**From:** Andrew Wood  
**Sent:** 13 January 2020 10:01  
**To:** Nicola Spencer  
**Subject:** FW: A/157/19/PL - Quiet Waters Angmering - Error in Decision Notice  
**Attachments:** 1006-Ang302-Proposed Ramp Design.pdf; Decision Notice 10.12.19.pdf

Pls see email below. There is an error in the decision notice attached in condition 1 where I referenced dwg.no. 1006-Ang 301 rather than dwg.no. 1006 – Ang 302.

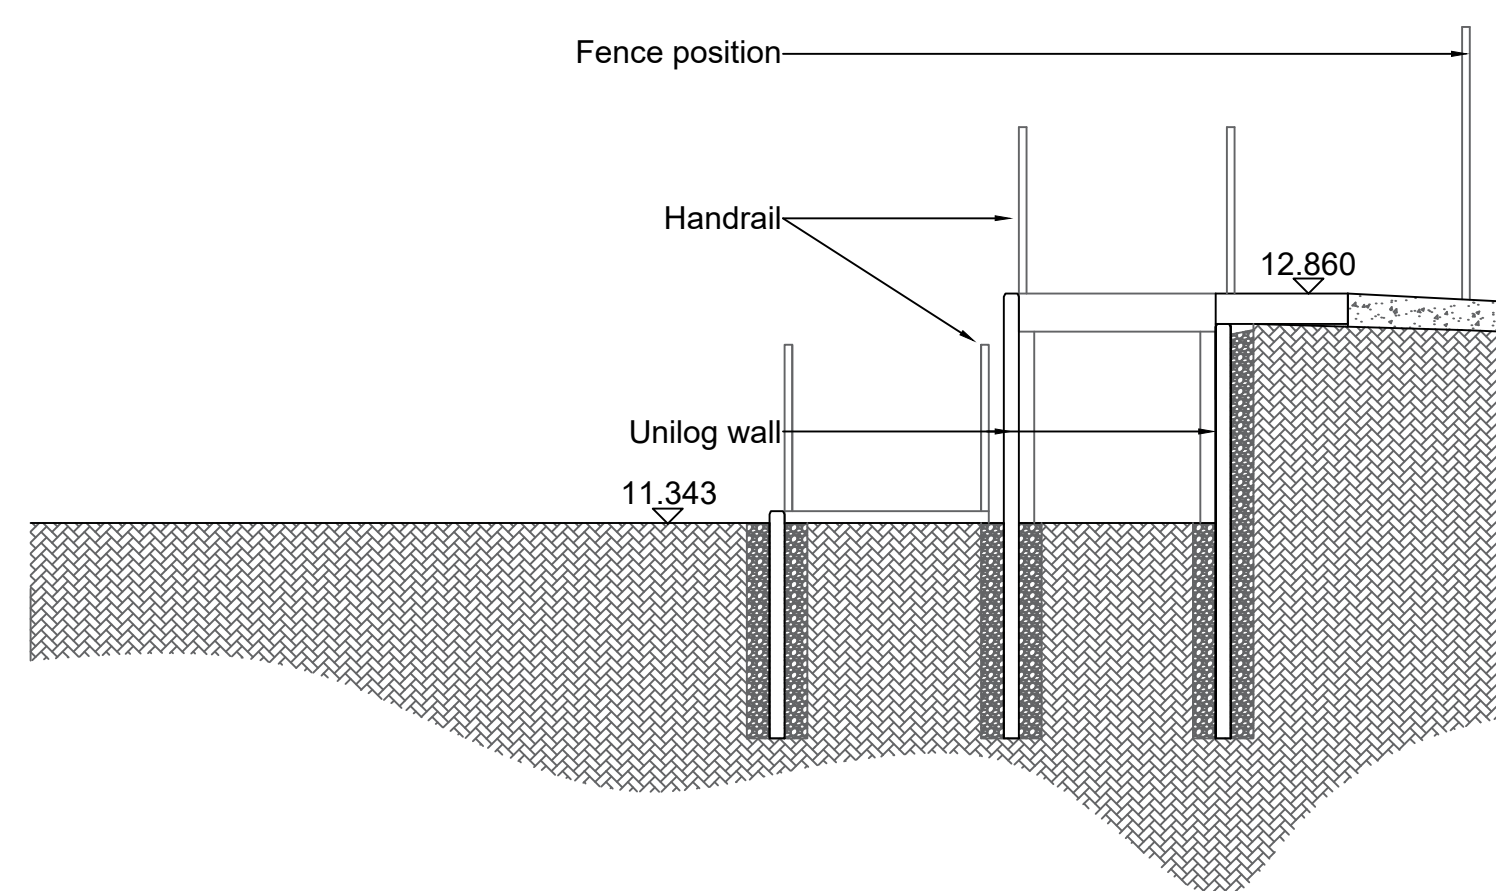
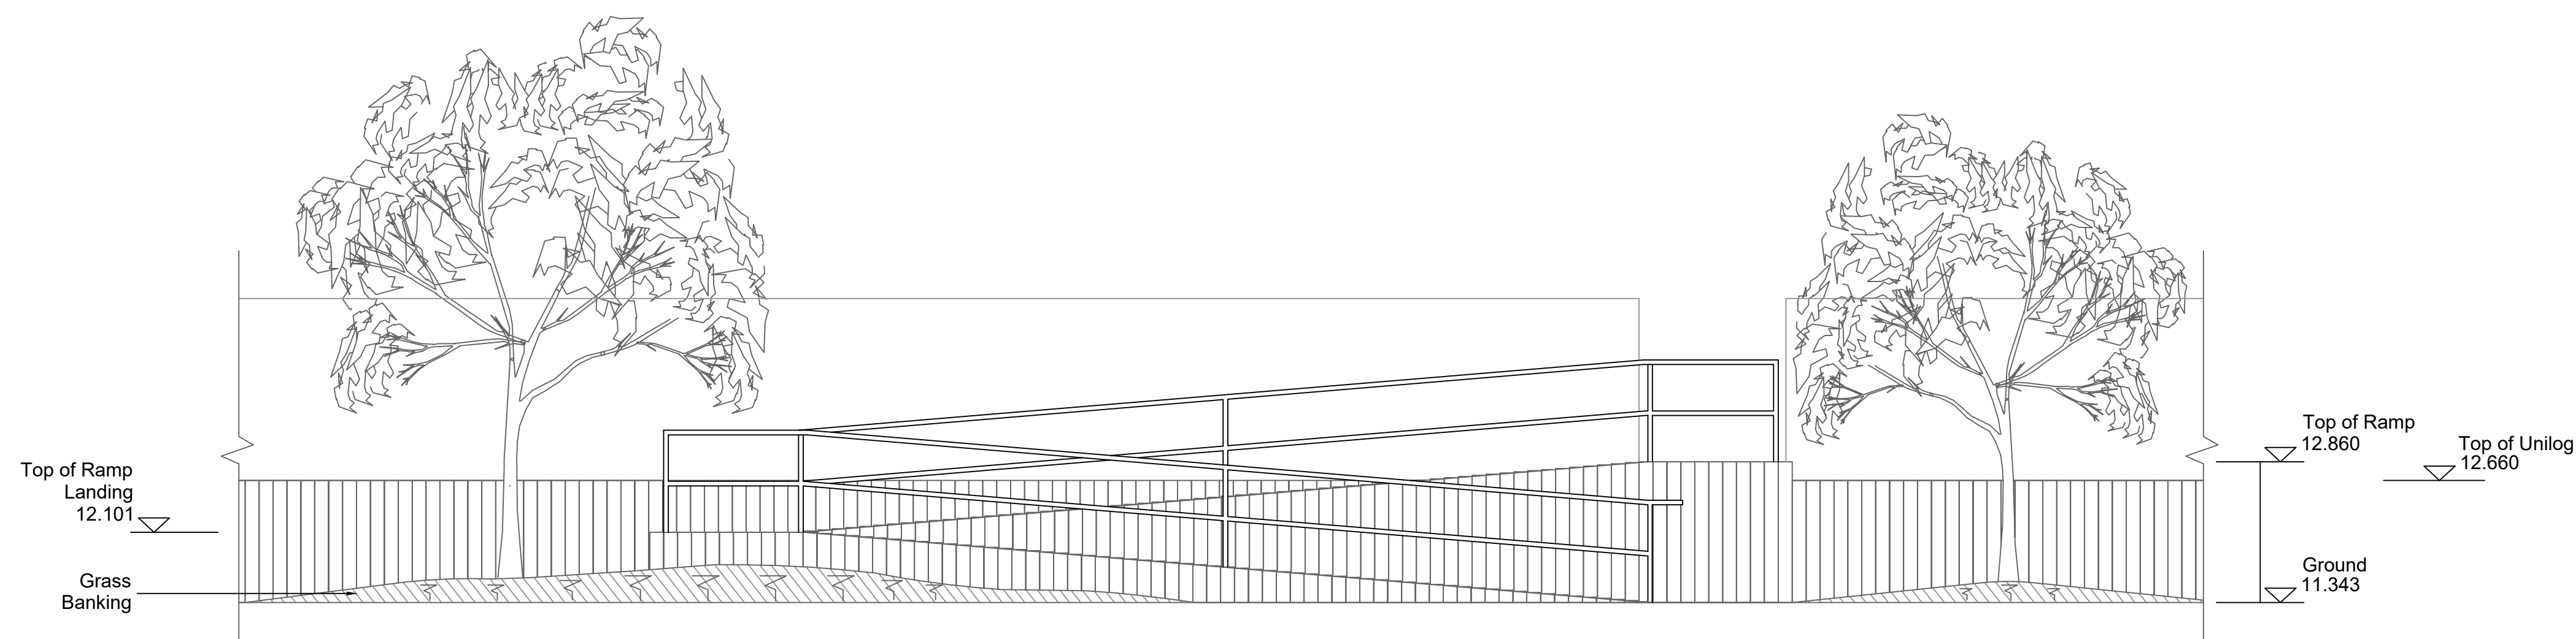
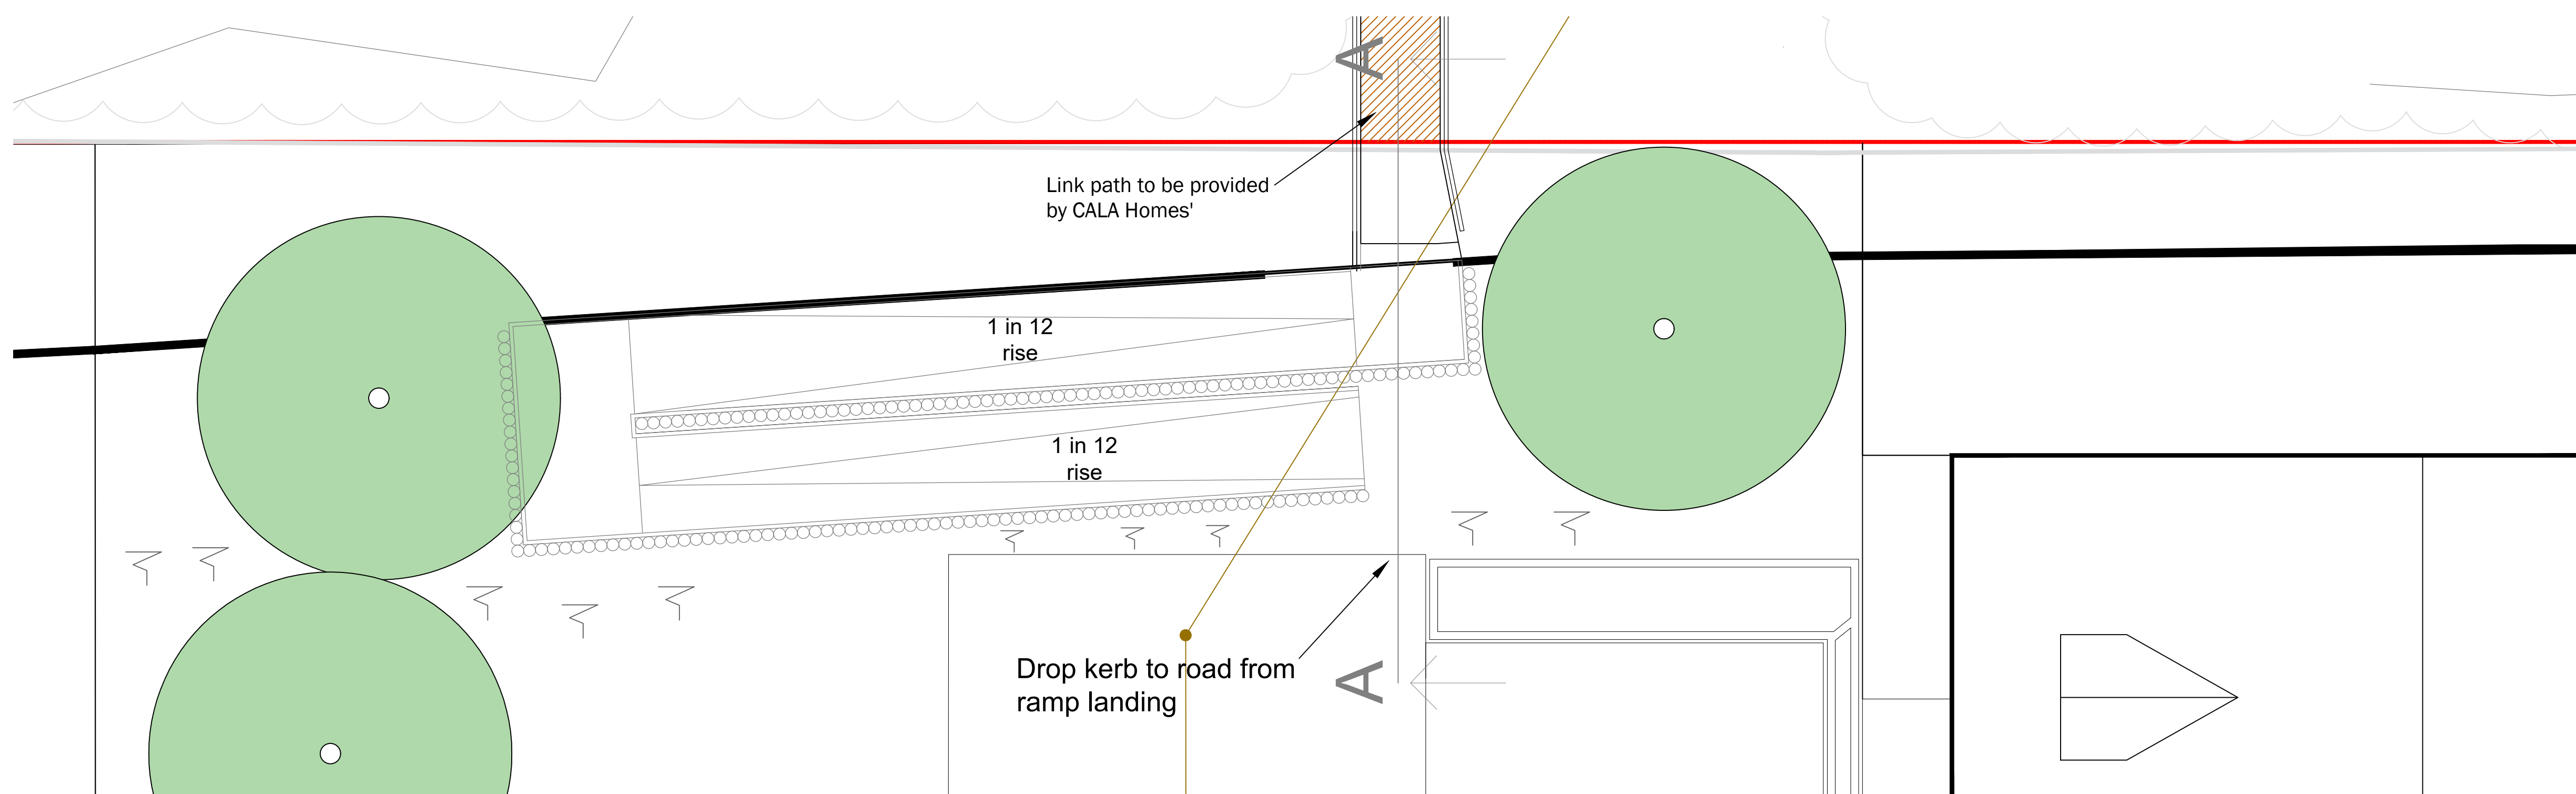
Further to our telephone conversation we note the structural engineer's comments, in which he acknowledges that the proposed Unilog retaining wall would be structurally adequate. However he queries whether the 25 year design life is adequate and asks "*is this considered appropriate for a public pedestrian footway and who will be responsible for the medium to long term maintenance of the wall and ramp?*"

As discussed, this is not a 'public pedestrian footway' – it is a pedestrian link on private land. The Unilog retaining structure proposed for the link is exactly the same as structure as has been approved for the retaining walls throughout the rest of the site and the medium to long-term maintenance will be the responsibility of the management company who will manage all of the common areas within the scheme.
